23/09/2025

Proposed Peartree Hill Solar Farm (Application Reference: EN010157)

Third notification of proposed changes to the DCO Application

Figure 1.2: Land Areas and Cable Routes Plan with Field Numbering System

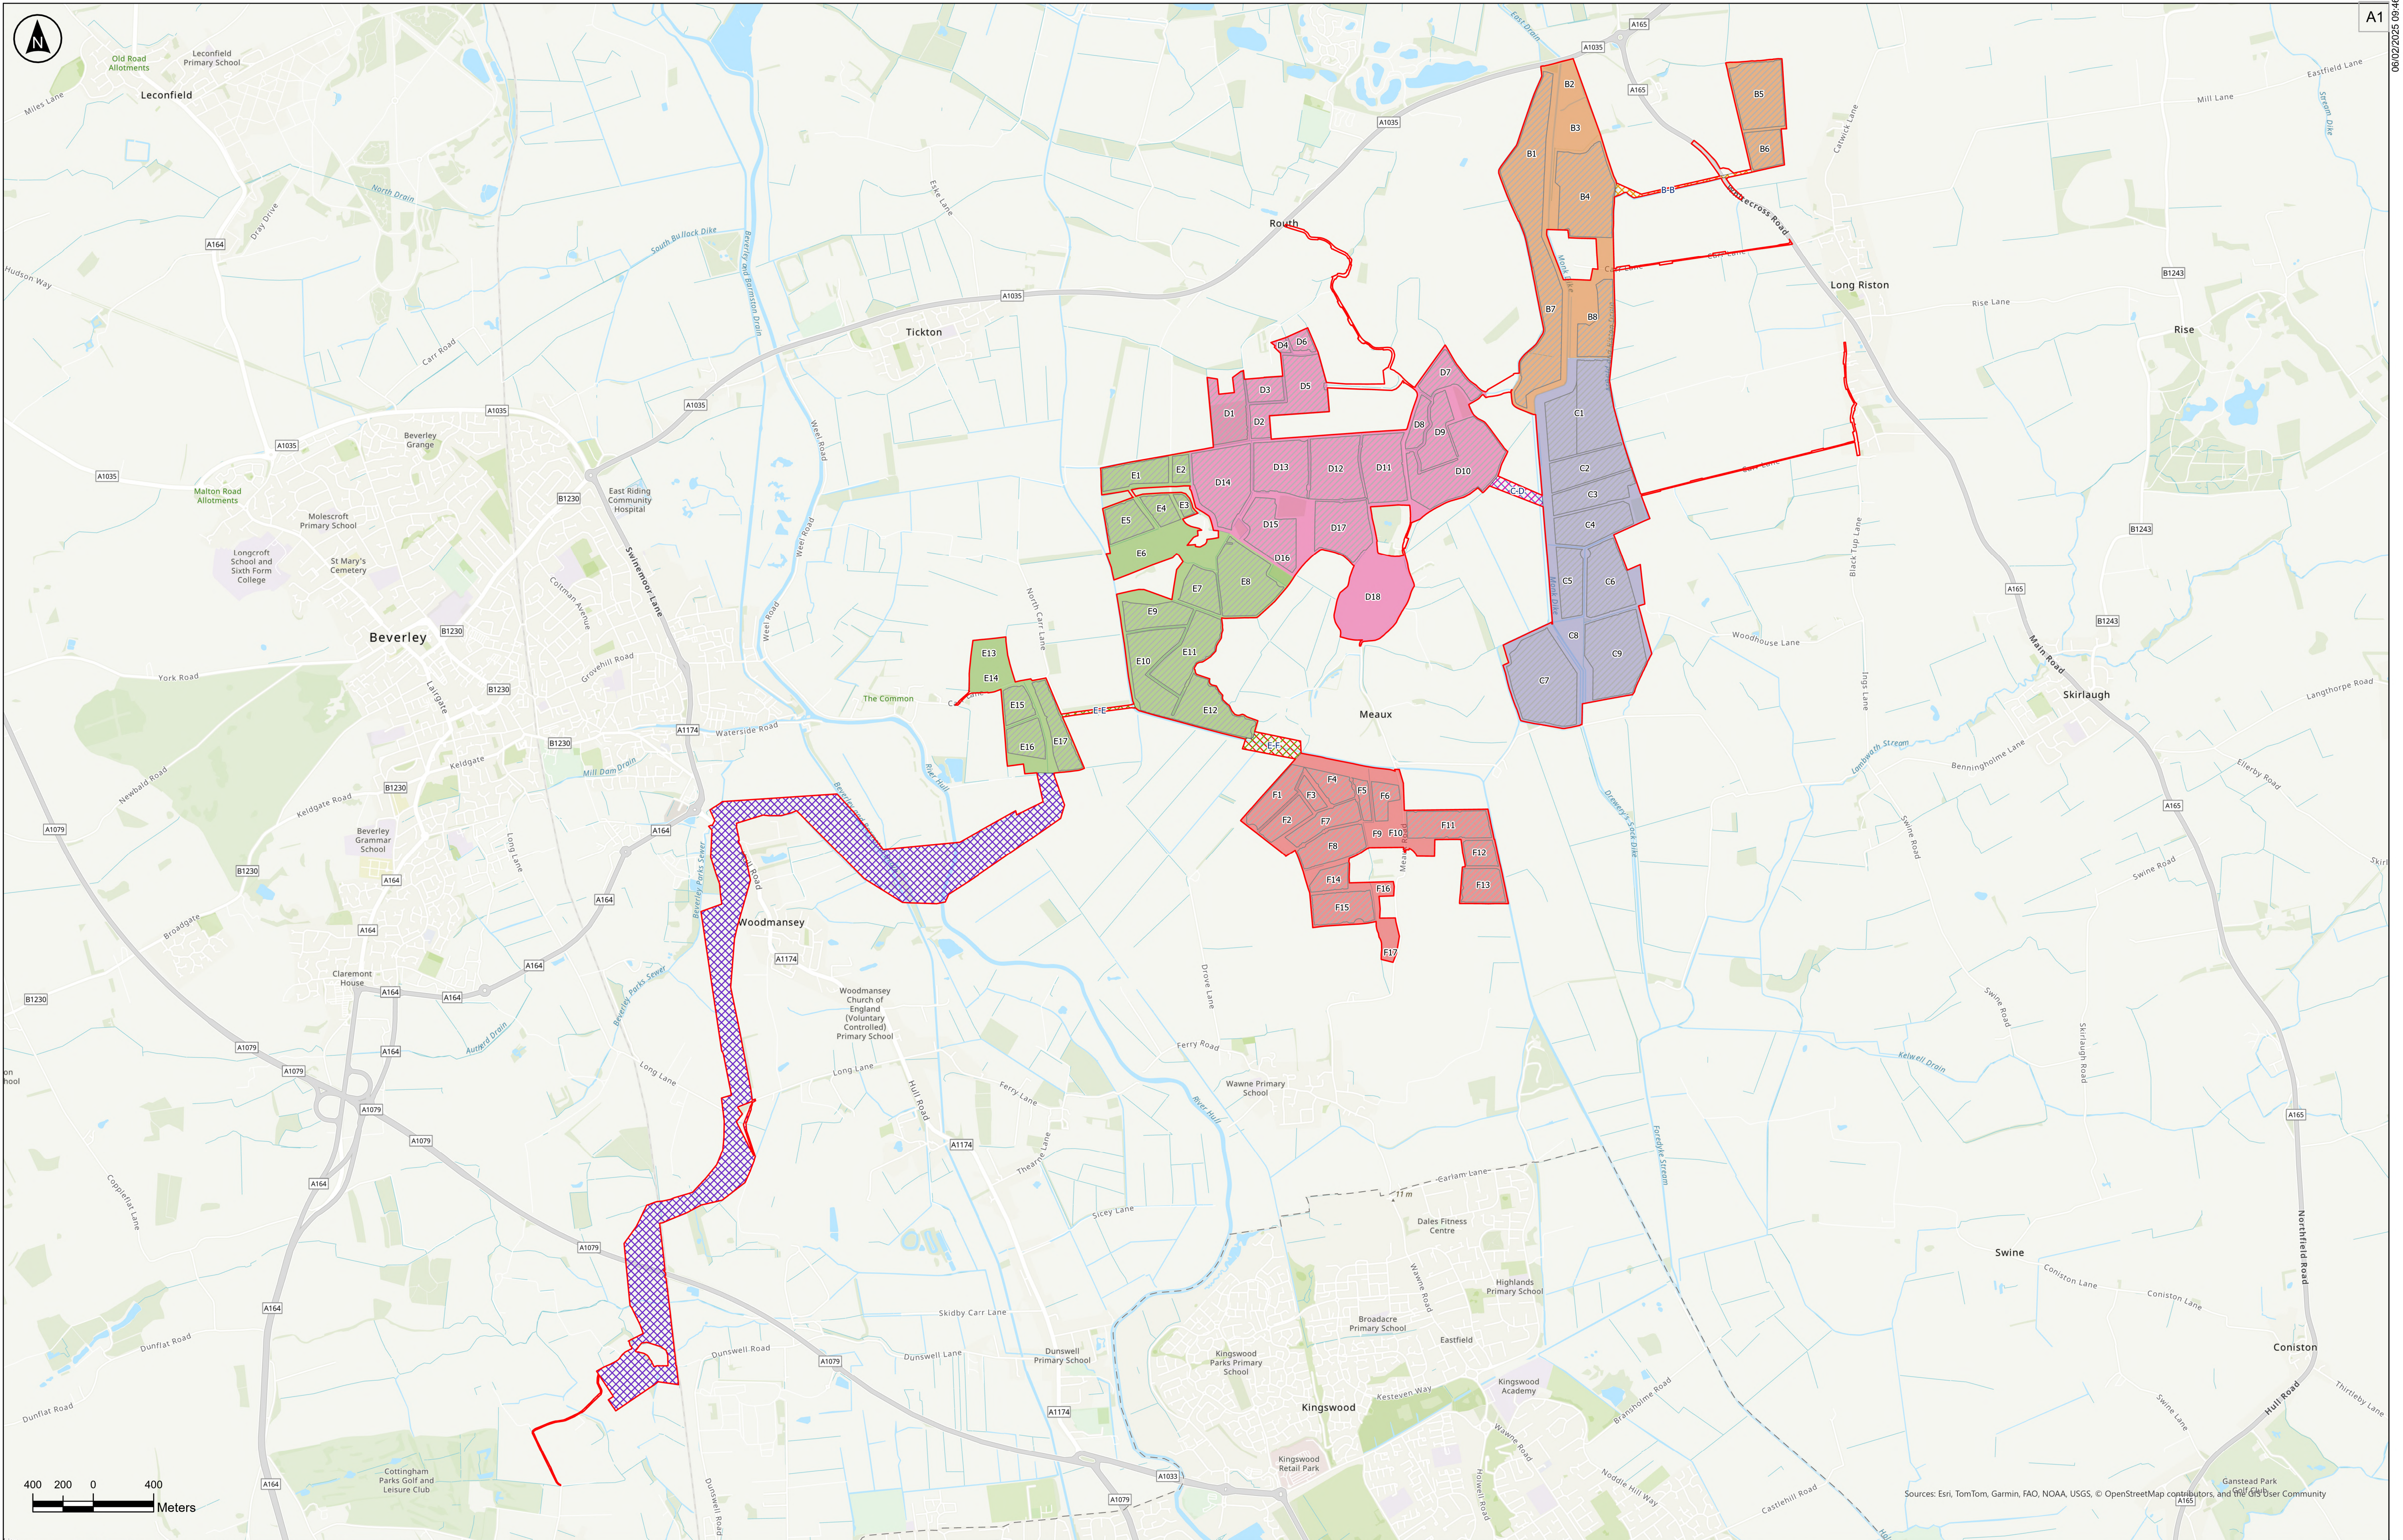
- a) **Change 10** – Change to permissive path route around Field D18.
- b) **Change 11** – Change to remove permissive path route around Field E6 and to extend permissive path route around Fields E7 and E8.

- c) **Change 12** – a package of analogous changes comprised of:
 - a. Moving the permissive path that runs through the proposed biodiversity mitigation area between Fields D16 and D17 closer to the edge of Field D16.

- b. Moving the permissive path in Field B2 closer to the eastern edge of this field.
 - c. Moving the permissive path at the north of Field B8 closer to the northern edge of the field so that it is to the edge of the proposed biodiversity mitigation area in this field.

- d. Moving permissive paths throughout Land Area F closer to the edge of the fields (this includes Fields F9, F10, F14 and F16).
- d) **Change 13** – The provision of additional post and wire fencing between permissive paths and ecological mitigation areas. The total length of the proposed additional post and wire fencing is approximately 6km and would be up to 1m in height.

Change number	Brief summary	Improvement to the DCO Application
10	<p>Change to permissive path route around Field D18.</p> <p>The DCO Application included a permissive path loop around Field D18, which would be available for horse riders. Field D18 has been identified as an ecological mitigation area for breeding and wintering bird species associated with the Humber Estuary SPA/Ramsar site.</p> <p>This change involves the removal of the permissive path loop around Field D18 but retention of a small section in the north-east corner of the field to allow access from Meaux Livery, on the other side of Meaux Lane, to the rest of the permissive path network. The retained section of path would still be available for horse riding.</p>	<p>Change seeks to address Natural England's concern of potential disturbance to SPA qualifying bird species arising from users of permissive paths (including dogs) having unrestricted access to Field D18.</p> <p>Permissive path route is now proposed in the north-east corner of Field D18 and is to be fenced off, thereby likely improving the efficacy of the proposed mitigation for the identified SPA species.</p>

11	<p>Removal of permissive path loop around Field E6 and extension of permissive paths around E7 and E8.</p> <p>Our DCO Application included a permissive path loop around Field E6, which has been identified as an ecological mitigation area for breeding and wintering bird species associated with the Humber Estuary SPA/Ramsar site.</p> <p>This change involves the removal of the permissive path loop around Field E6; re-location of the section of permissive path along the east of Field E6 to the other side of the hedge, to prevent access to Field E6, and extending the path around Fields E7 and E8 to join up with the rest of the network.</p> <p>This change would compensate for the loss of permissive path loops around Field E6 and D18.</p> <p>The new permissive path route would be made available for horse riding.</p>	<p>Change seeks to address Natural England's concern of potential disturbance from users of permissive paths (including dogs) to SPA qualifying bird species arising from proposed permissive paths in DCO Application.</p> <p>The extension of the permissive path around the south of Fields E7 and E8 ensures that the reduction in the total length of the permissive path network is kept to a minimum and maintains the connectivity of the proposed permissive path network across the site of the Proposed Development.</p>

Change number	Brief summary	Improvement to the DCO Application
12	a) Moving the permissive path that runs through the proposed biodiversity mitigation areas between Fields D16 and D17 closer to the edge of Field D16. The realigned section of path would still be available for horse riding.	Change seeks to minimise potential disturbance from users of permissive paths (including dogs) to ground nesting bird species, while maintaining the proposed permissive path route in Fields D16/D17 and the overall connectivity of the proposed permissive path network.

b) Realignment of permissive path in Field B2 to run closer to the eastern edge of this field.	Change seeks to minimise potential disturbance from users of permissive paths (including dogs) to ground nesting bird species, while maintaining the proposed permissive path route in Field B2 and the connectivity with the existing Riston Footpath No. 2.

c) Moving permissive path at the north of Field B8 closer to the northern edge of the field, to the edge of the proposed biodiversity mitigation area in this field.	Change seeks to minimise potential disturbance from users of permissive paths (including dogs) to ground nesting bird species, while maintaining the proposed permissive path route in Field B8 and the connectivity between Carr Lane and the existing Riston Footpath No. 2.

d) Moving permissive paths throughout Land Area F closer to the edges of the fields (namely in Fields F9, F10, F14 and F16).	Change seeks to minimise potential disturbance from users of permissive paths (including dogs) to ground nesting bird species, while maintaining the proposed permissive path route throughout Land Area F and the overall connectivity of the proposed permissive path network.
13	<p>Installation of post and wire fencing between permissive paths and ecological mitigation areas.</p> <p>The total length of the proposed additional post and wire fencing is approximately 6km and would be up to 1m in height.</p>	<p>This will provide further protection for ecological mitigation areas located along the permissive path routes from disturbance by users of the paths.</p> <p>Fencing will be accompanied by signage highlighting the reasons for it and the purpose of the mitigation areas, including information on relevant bird species for the benefit of permissive path users.</p> <p>Due to the fencing's low profile, no significant landscape and visual effects are anticipated as a result of the proposal.</p>

Change 10 – Field D18 is intended to provide ecological mitigation areas for areas of functionally linked land for the relevant bird species associated with the Humber Estuary SPA/Ramsar site. In order to address concerns raised regarding the potential disturbance to birds arising from users of permissive paths (including dogs) having unrestricted access to the identified ecological mitigation areas, the Applicant has proposed the removal of the permissive path around the majority of Field D18.

Change 11 - Field E6 is intended to provide ecological mitigation for areas of functionally linked land for the relevant bird species associated with the Humber Estuary SPA/Ramsar site. In order to address concerns raised regarding the potential disturbance to birds arising from users of permissive paths (including dogs) having unrestricted access to the identified ecological mitigation areas, the Applicant has proposed the removal of the permissive path around Field E6.

Change 12 – The minor amendments that make up change 12 (i.e. moving proposed permissive paths to the edges of Fields F9, F10, F14 and F16) are proposed in order to reduce potential disruption from users of the proposed permissive paths to the ecological mitigation areas for ground nesting birds.

Change 13 – The Applicant proposes to install post and wire fencing between permissive paths and ecological mitigation areas. This will provide further protection for ecological mitigation areas located along the permissive path routes from disturbance by users of the paths. The total length of the proposed additional post and wire fencing is approximately 6km and would be up to 1m in height.
